From: ZAK JOMAA [REDACTED]
Sent: 07 April 2022 01:04
To: Kathryn Welch
Subject: Re: R/32/22/HH
Attachments: 30 The Parkway - Proposed Block Plan- April 2022.pdf; 30 The Parkway - Existing Block Plan- April 2022.pdf; BN162BU - TREE TPO.JPG; ADC PARKS & GREENSPACE ARBORICULTURE.pdf

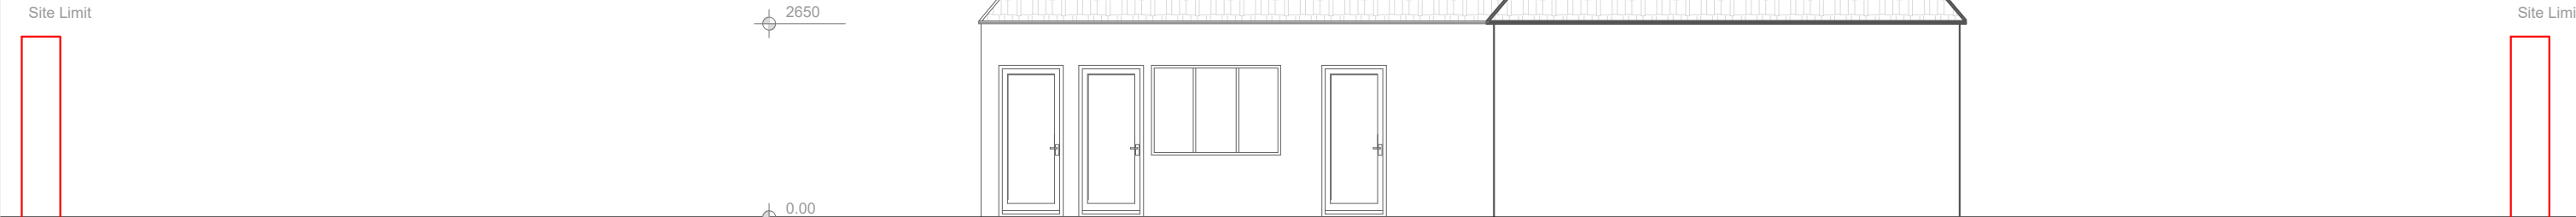
- The northern elevations do not show the proposed garage in the back ground.
- The rear elevations denotes the garage extension to be an 'Annex conversion'. Can you confirm and amend as appropriate.
- The rear elevation and block plan show differing distances of the garage extension to the southern boundary. Can you amend as appropriate.
- Can you please show the extent to the Root Protection Area and position and diameter of the trunk of the TPO tree on site. Can this be shown on your block plan.

PROJECT NAME | House extension at 30 The Parkway, Rustington, BN16 2BU, UK
DRAWING TITLE | Planning Application Drawing - Proposed Block Plan 1/500

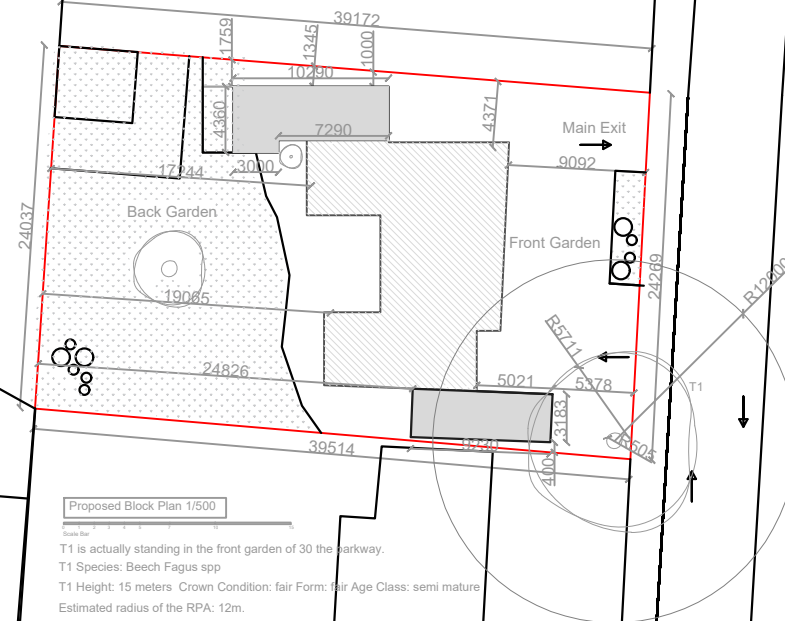
Many thanks for the plans, however when I was on site today I noted the large beech tree on the shared boundary with No 32 The Parkway. This tree is protected with a TPO and I'm required to know how much building works will be undertaken within its root protection area (RPA), from my visit I estimate the radius of the RPA to be 12m.

In order to satisfactorily determine the application I still require the exact positioning of the tree on plan with its RPA denoted and any other information pertaining to the tree which you may feel of use to me.

Many thanks for visiting the site and getting back with comments. I have added the tree protected with TPO to the existing block plan and proposed block plan.

- T1 is actually standing in the front garden of 30 the parkway.
- T1 Species: Beech Fagus spp
- T1 Height: 15 meters Crown Condition: fair Form: fair Age Class: semi-mature
- The estimated radius of the RPA: 12m
- Tree Preservation Order - TPO/R/1/01
